DECISION DELEGATED TO HEAD OF PLANNING

Application No: H22-0570-24 **Applicant:** Mr R Scott
Proposal: Single storey rear extension to create a new lounge
Location: 8 Pentelow Way Weston Spalding
Terminal Date: 28th August 2024

Drawing No.
4131 Ricky - 01
Drawing Title:
Proposed Information

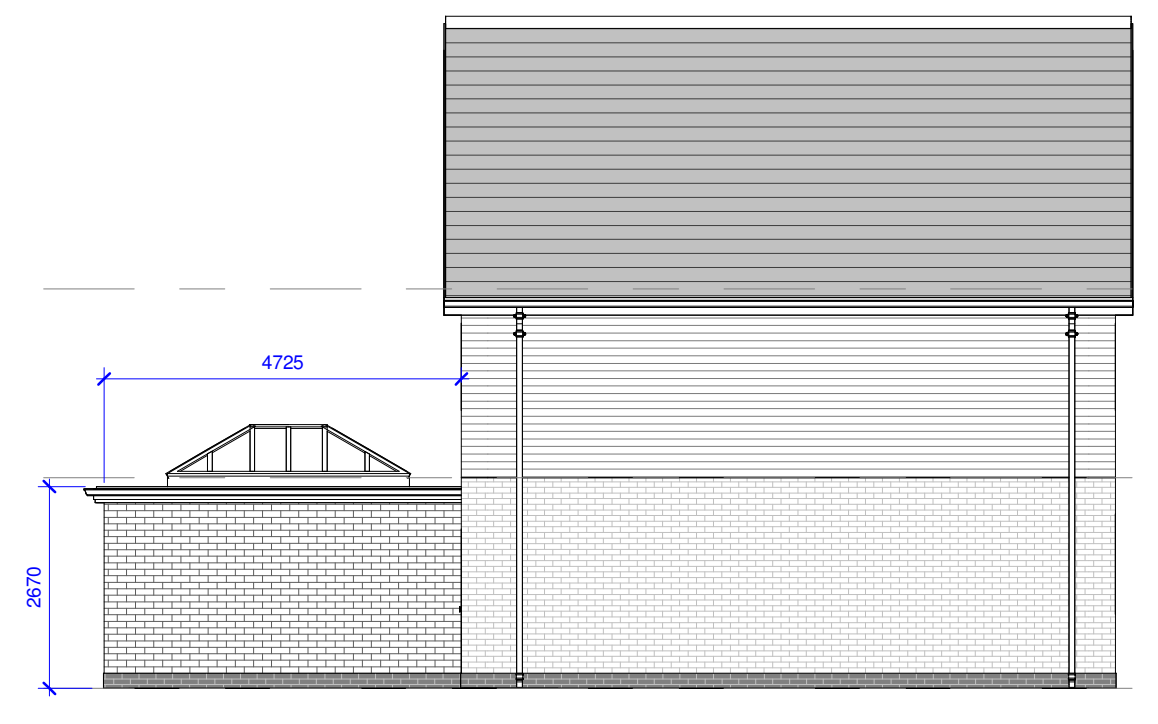
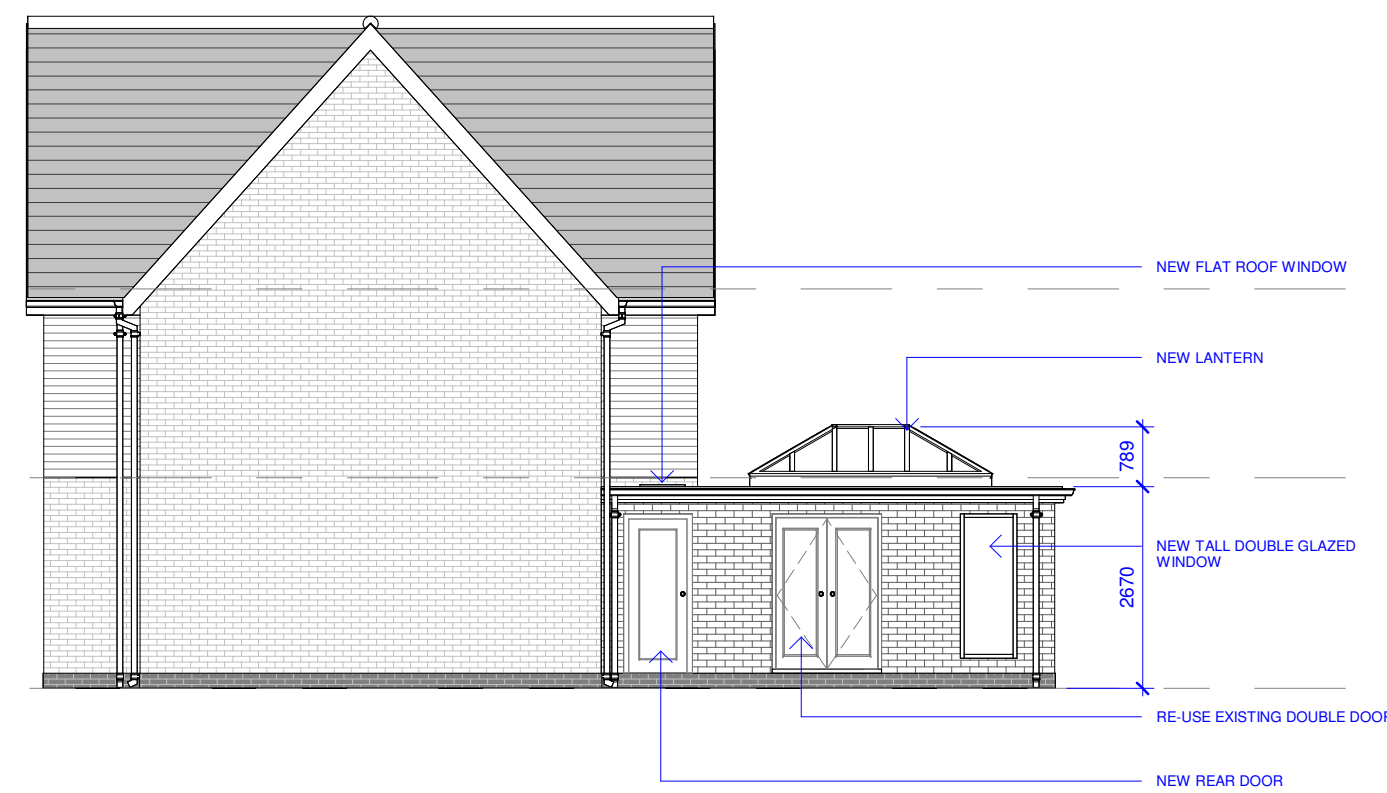
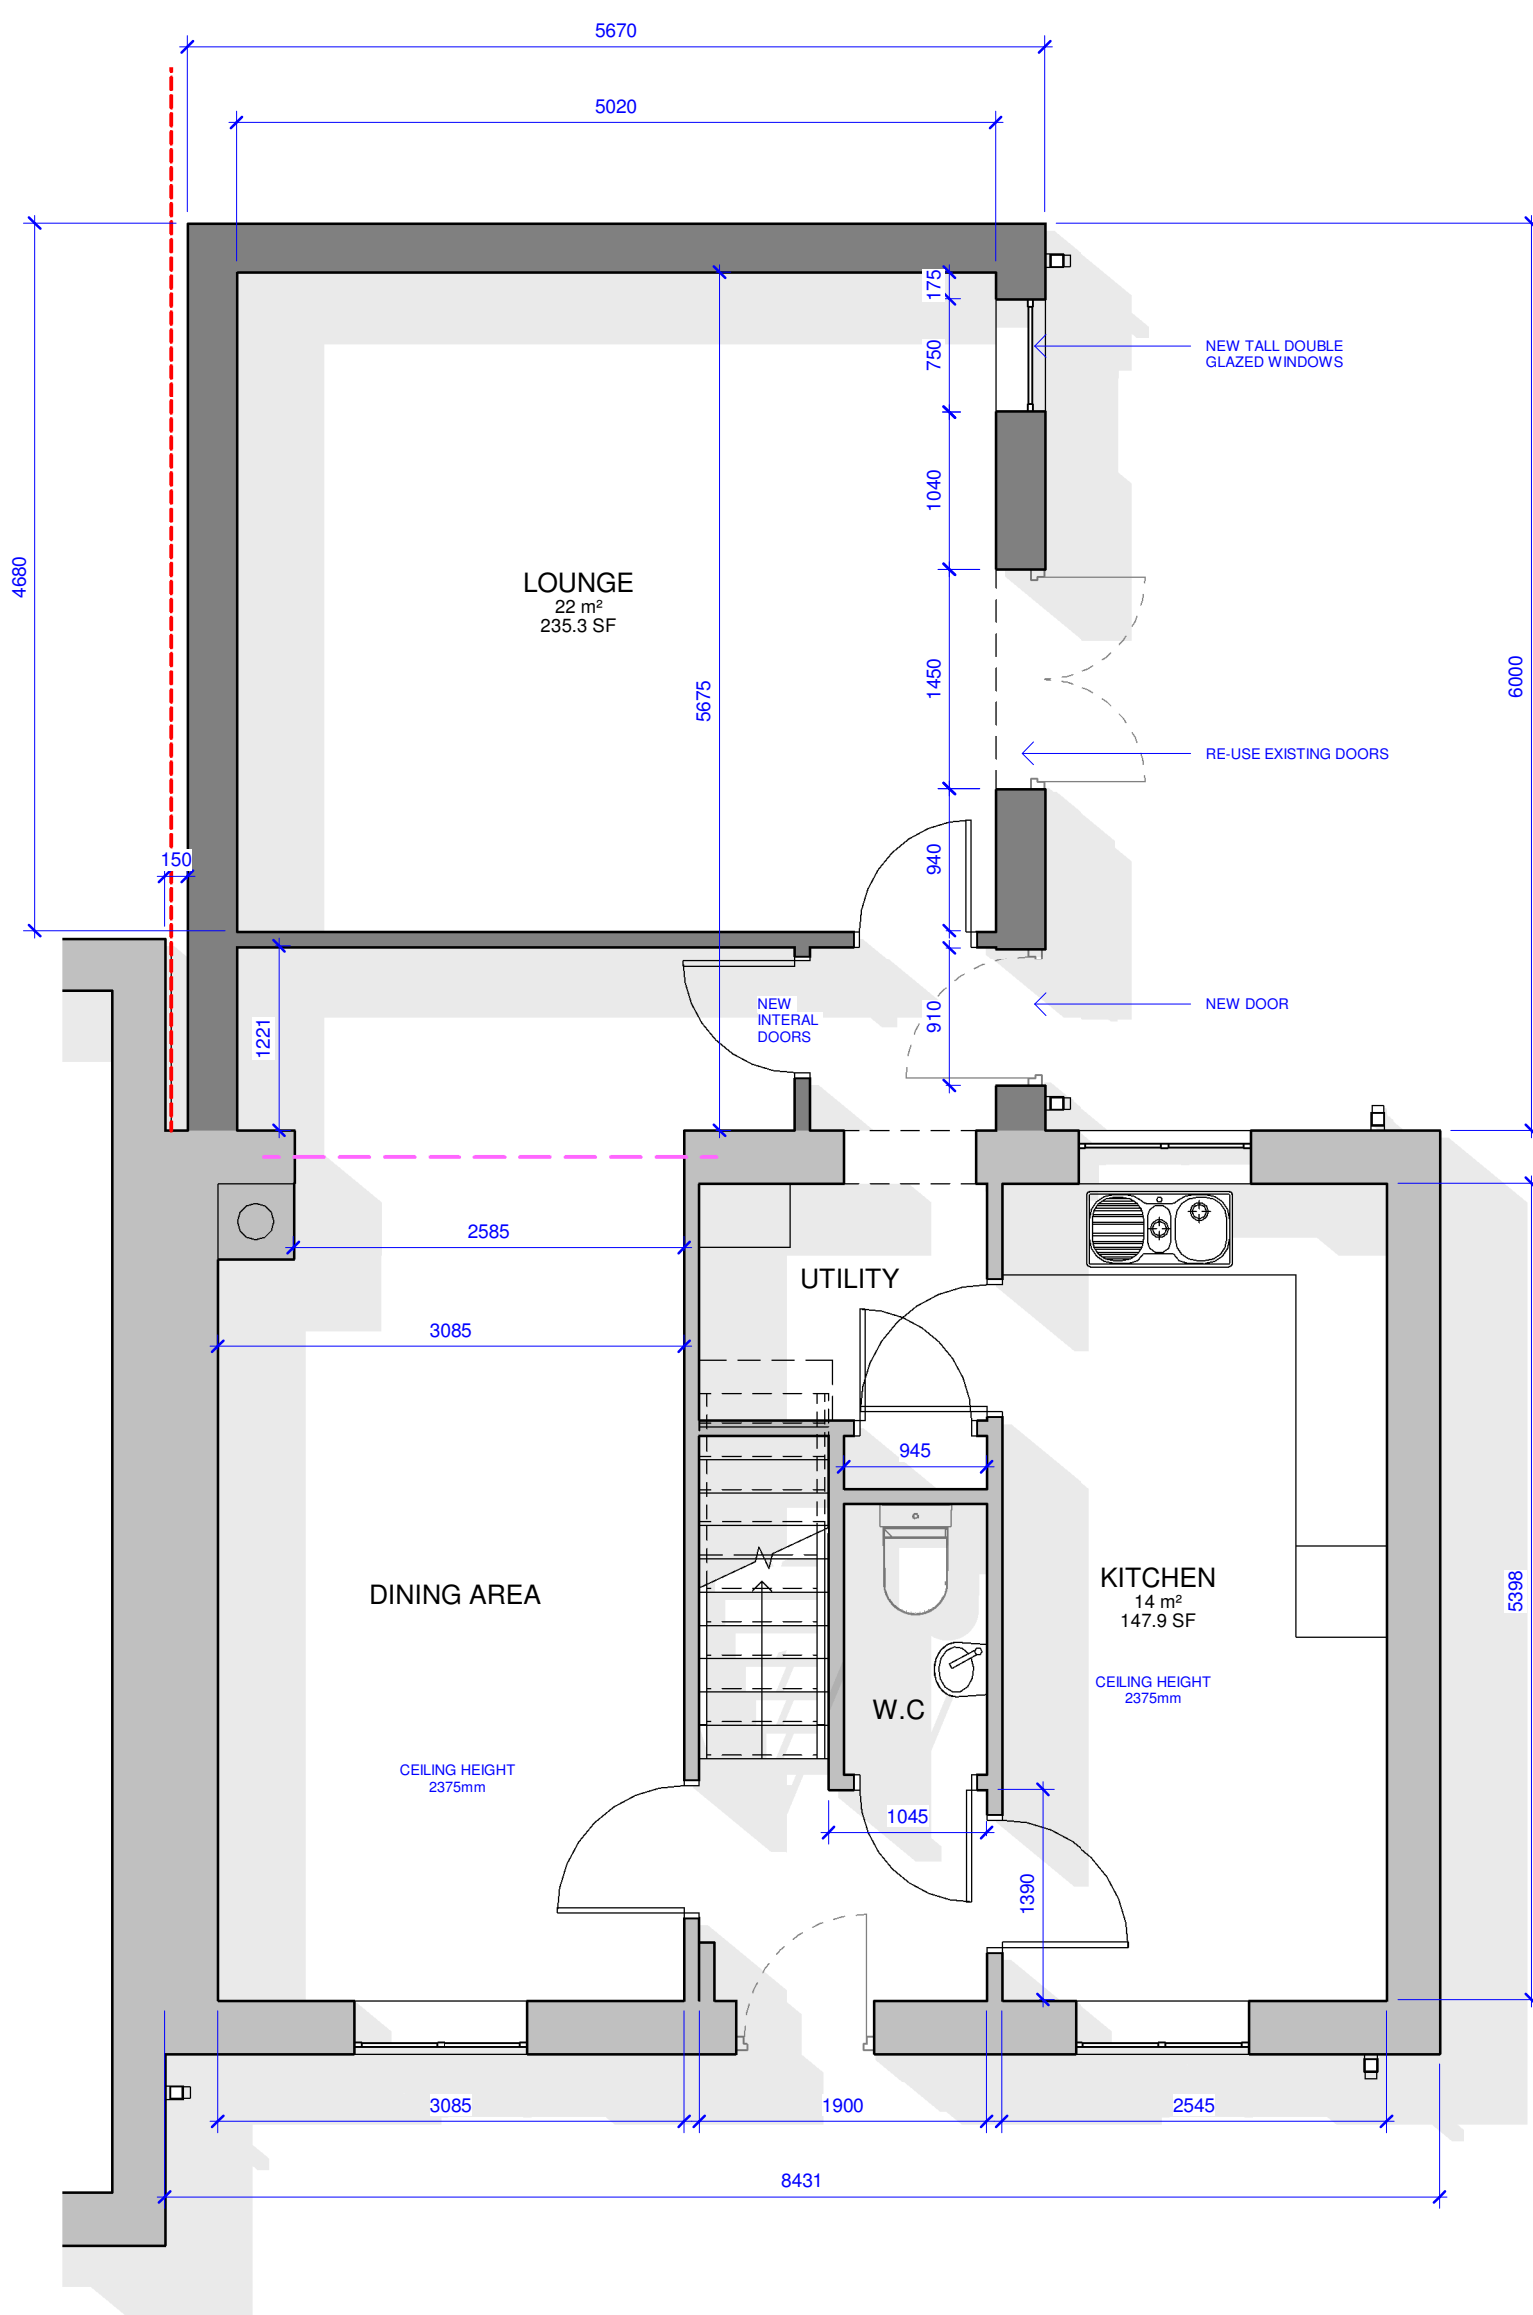
The proposed extension would not be readily visible from the street; and therefore, the impact upon the character is low. Moreover, the use of matching materials further reduces the potential impacts of the development. The proposed scale of development would be subservient to the host, reducing any impacts further.

The proposal would result in some loss of light to the neighbouring dwelling, due to the proximity to the adjacent rear doors. That being said, these doors connect onto a kitchen/dining room. While it is acknowledged that this room would be used fairly often, from a planning perspective the impact is not considered to be significant to warrant refusal. This room would primarily be used during the evening during the preparation of meals, and therefore, due to the east-west orientation of the buildings, the shadow created by the proposed extension at this time would be relatively low. Therefore, the impacts of the development would not be considered to be overly detrimental. Additional windows are present in the kitchen to ensure light could enter regardless.

-Proposed Roof Plan
1 : 50

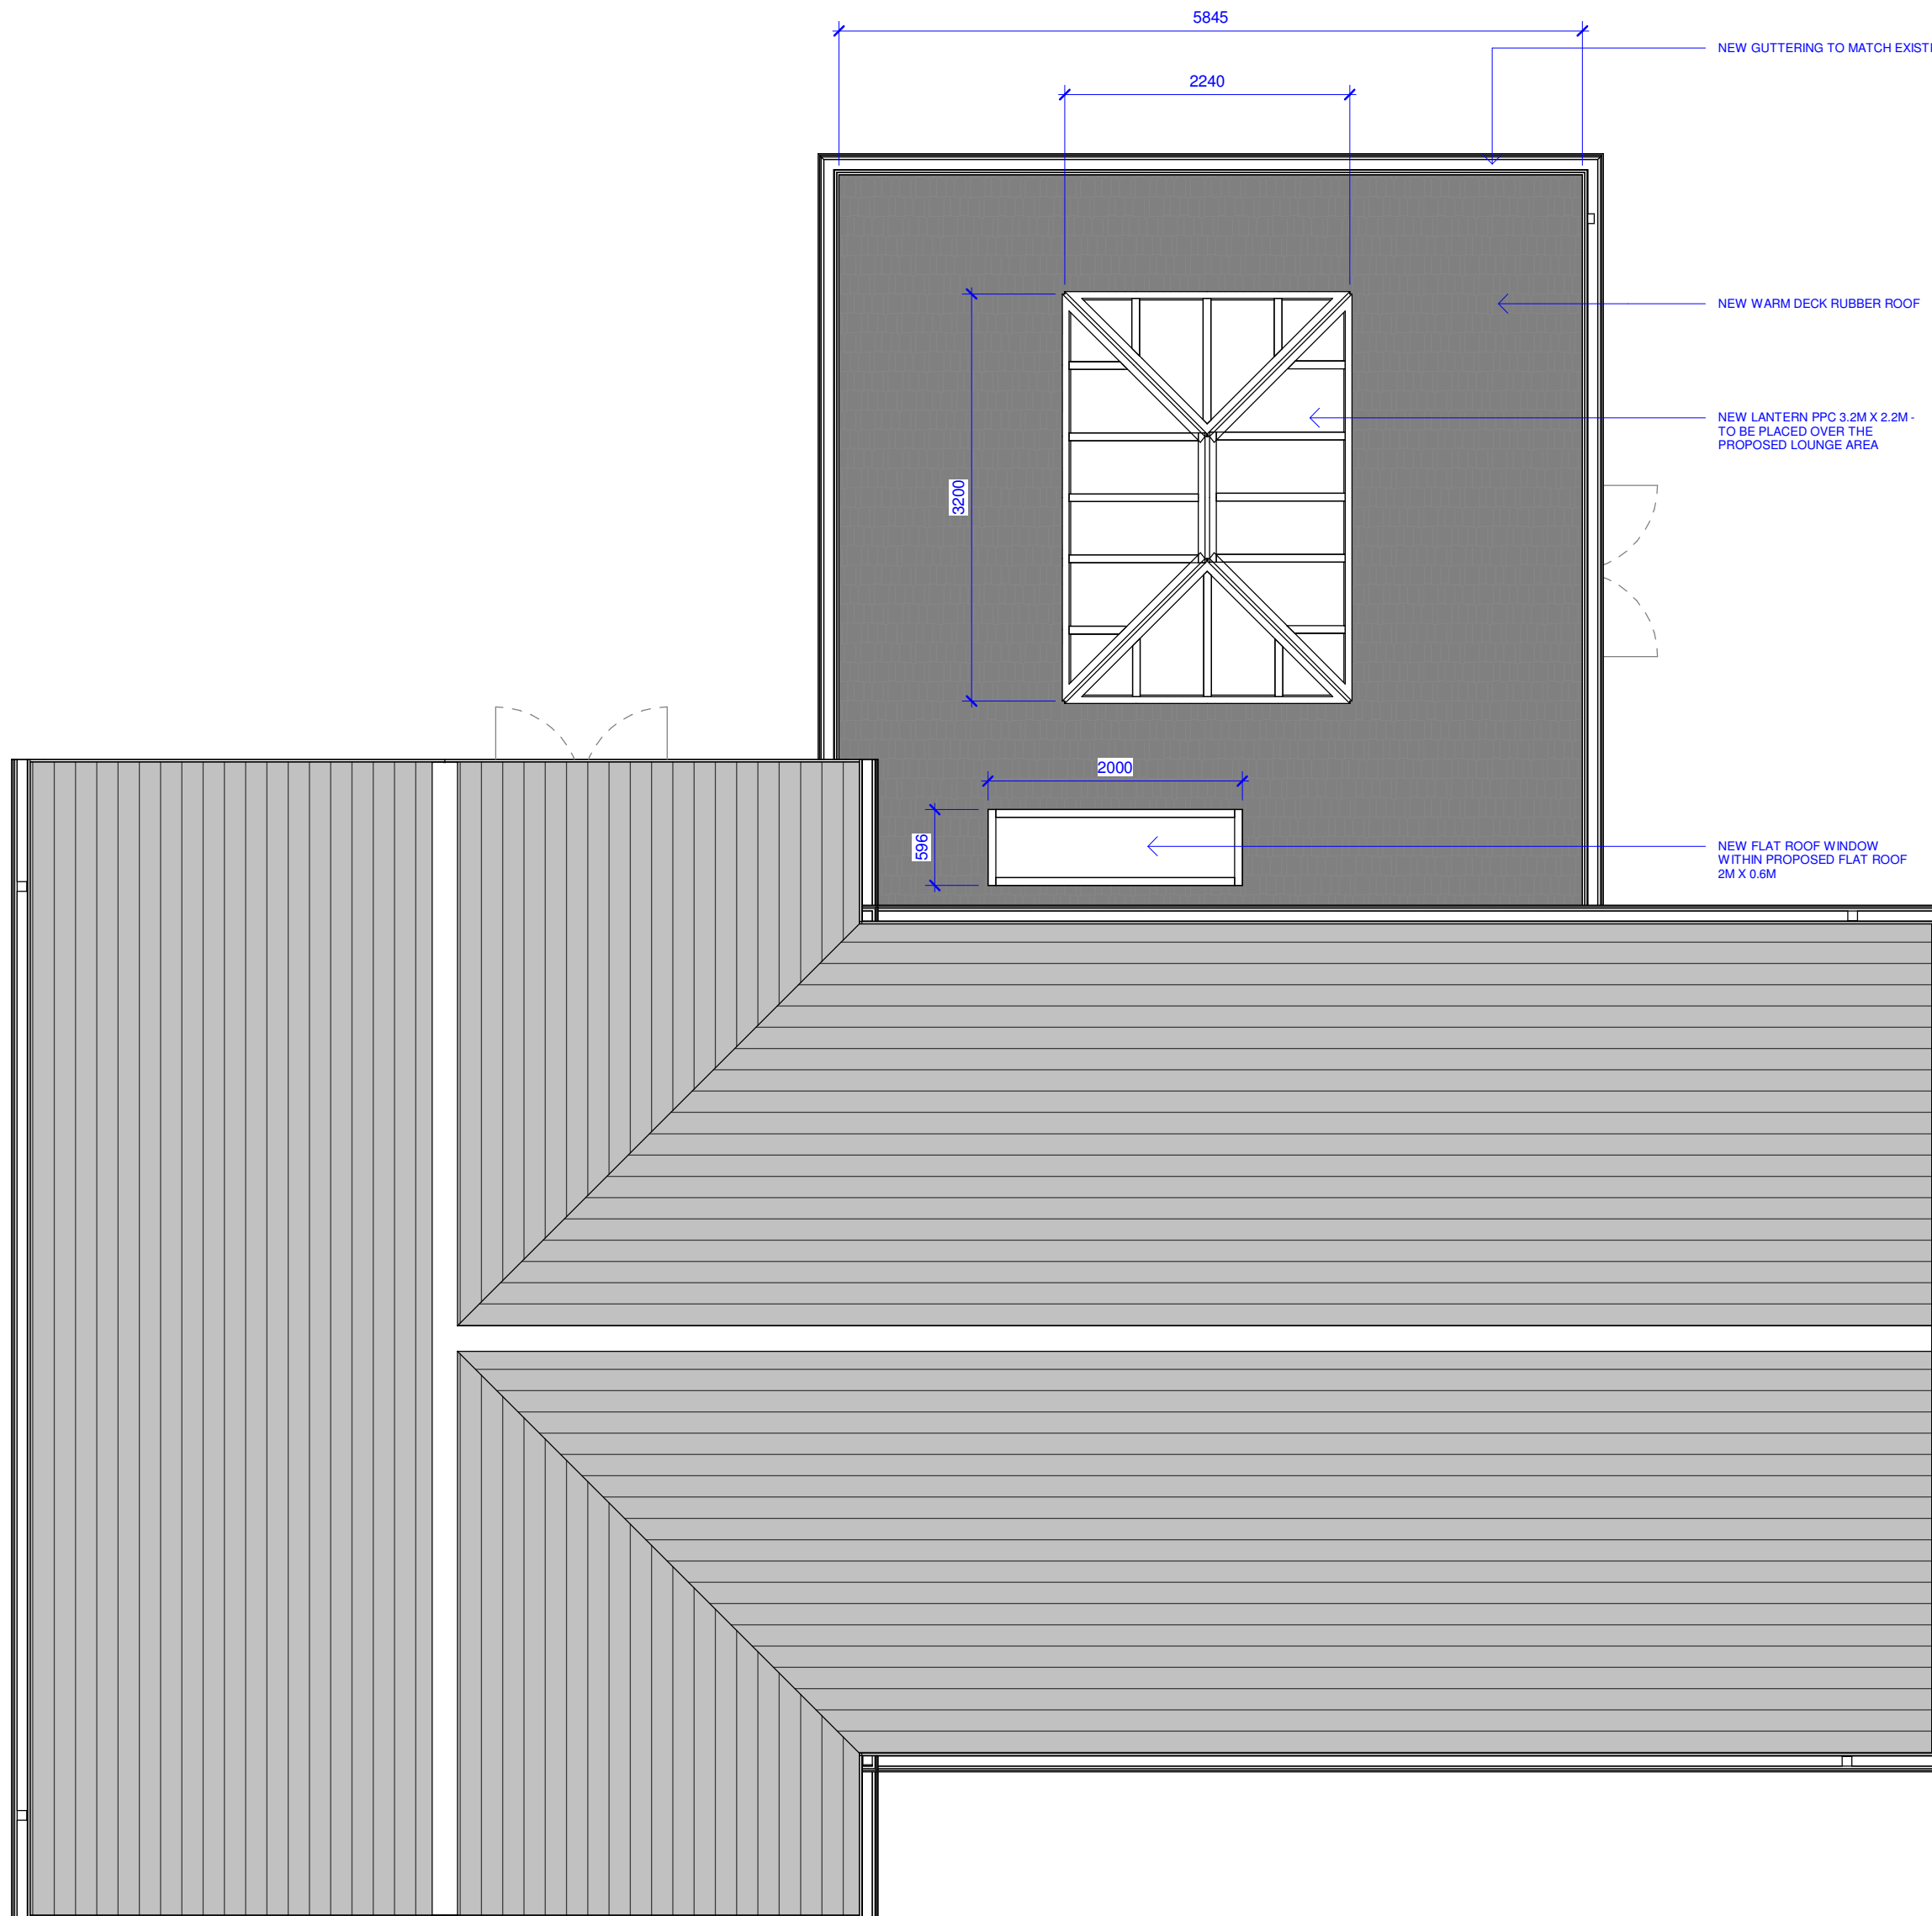
The proposal seeks planning permission for the erection of a single storey, flat roof, rear extension at 8 Pentelow Way. The extension would have a depth of 6000mm with a width of 5670mm. The extension would have a height of 2670mm. The extension would feature a projecting roof light,

along with two west facing doors and window. It is proposed that the brickwork and windows/doors would match the host, while black rubber is proposed for the flat roof.

The proposed skylight would be located at an angle of between 20 and 40 degrees from first floor south facing window of 2 Balderson Court. At the distances proposed, views could be obtained both into the proposed extension from the neighbouring dwelling and into said neighbouring dwelling. Therefore, the tangible risk of increased overlooking is significantly reduced.
